**From:** [Holly Erdman](#)  
**To:** [Rachael Stevie \(CD\)](#)  
**Subject:** RE: BL-20-00018 - Whitman Transmittal of Comments & Request for Additional Information  
**Date:** Tuesday, August 25, 2020 10:19:12 AM  
**Attachments:** [image001.png](#)

Thank you for the additional information you provided on this project. We are requiring that the proposed lot line be moved so that the existing well will be 50 feet from the new property line. This will ensure that when lot 2 is sold, the well on lot 1 will be in compliance with current regulations.

Site Plan

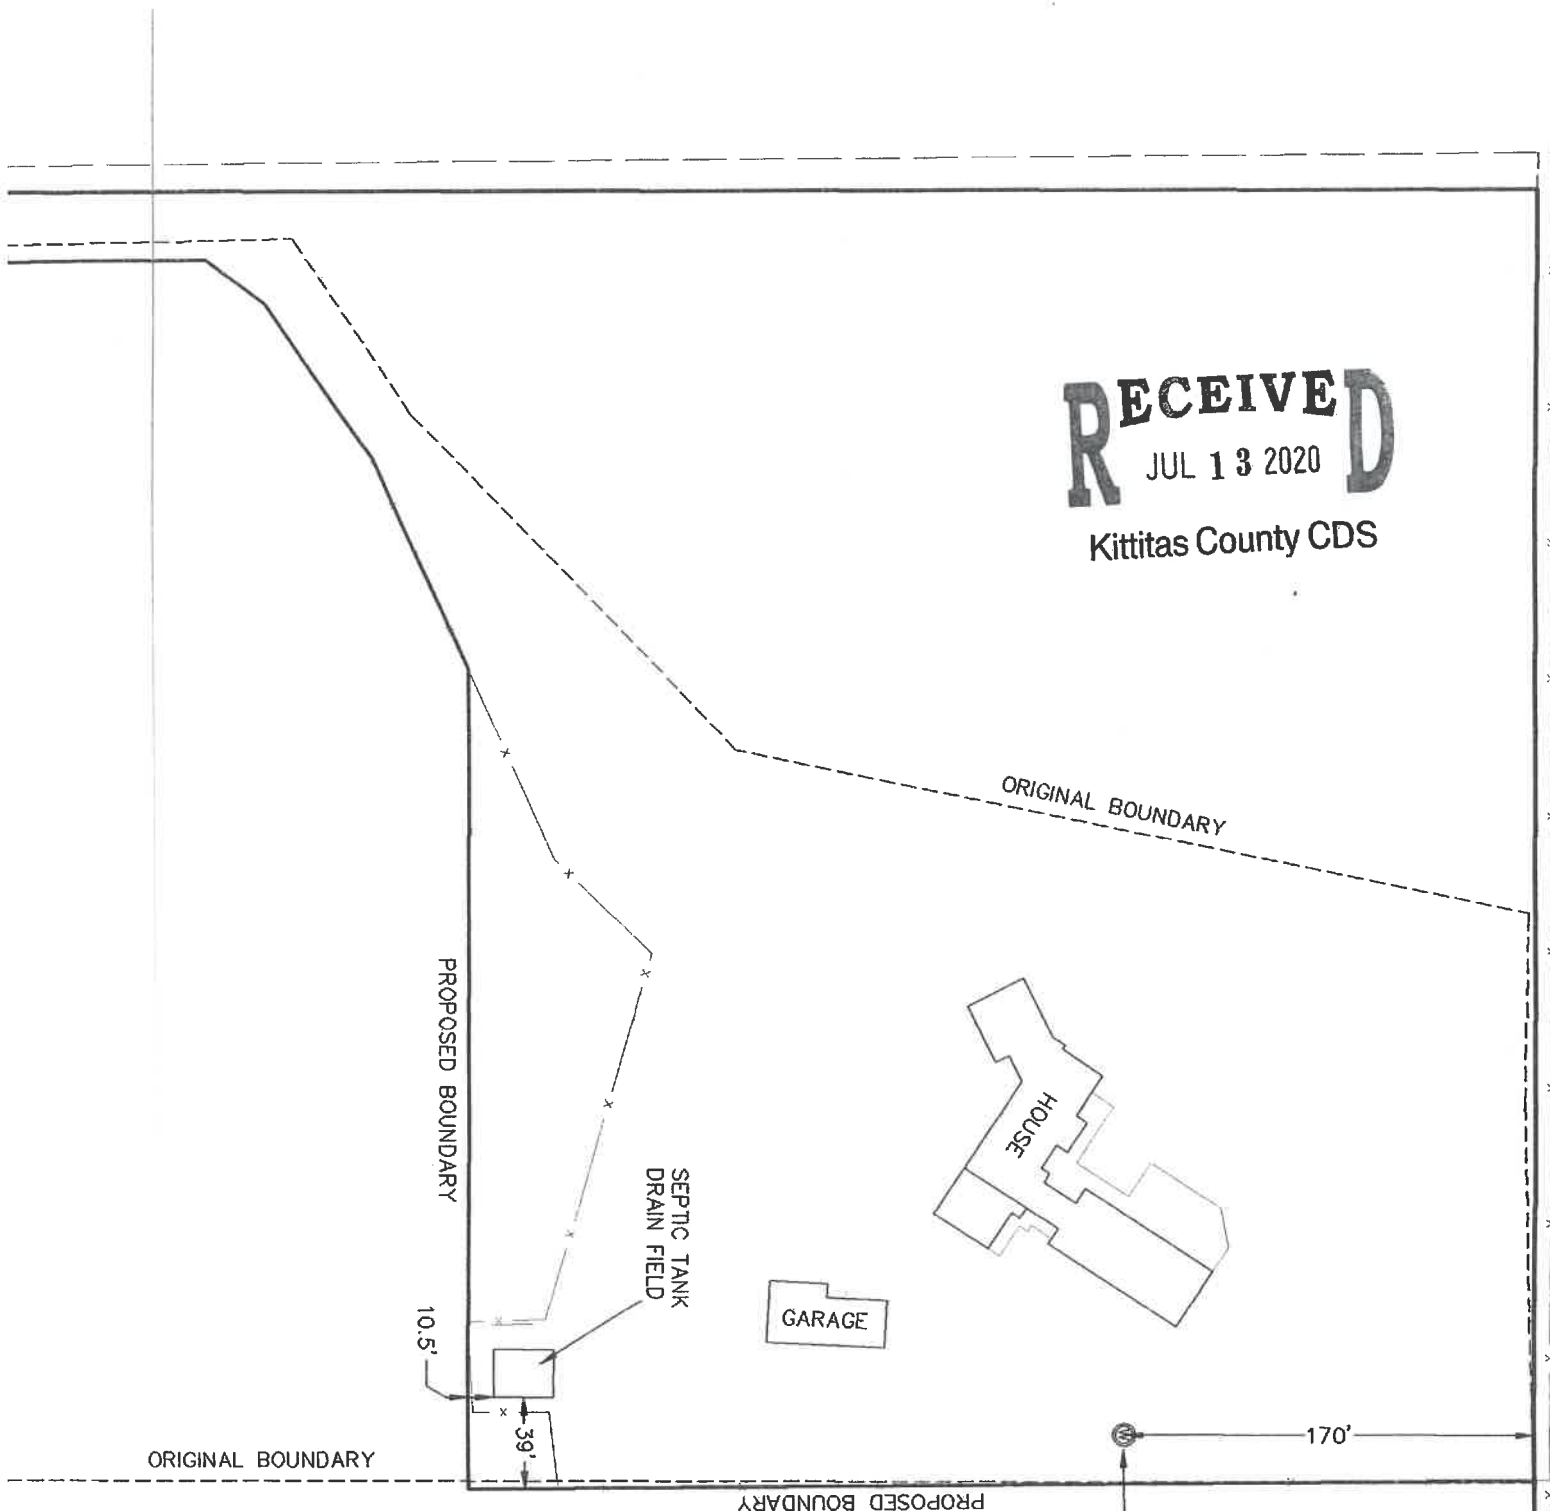
Can I confirm with you that if the applicant leaves the existing boundary line where it is (19.7'), he may *not* proceed with the BLA? The only way he can proceed with the BLA is if he moves the boundary line to 50' from the well?

Can you please advise whether the applicant should leave boundary line at 19.7' from the well as it sits currently, or if they may move it further away to 20' from the well?

Rachael – Below is a link to the original site plan submitted. Currently the existing property boundary is 19.7' from the well. We are proposing to move the boundary farther away from the well to make it more conforming but can not meet the 50' set back. Based on past enforcement we could always make boundaries more conforming even if it does not meet code. If we are not allowed to move the boundary farther from the well we could update our application to not adjust this boundary and leave it at 19.7' from the well to be able to proceed. Please contact me back with what is required and I will update the layout if needed.

Jesse got involved with this one last week and we decided to let them move it to 20 feet as they had proposed.
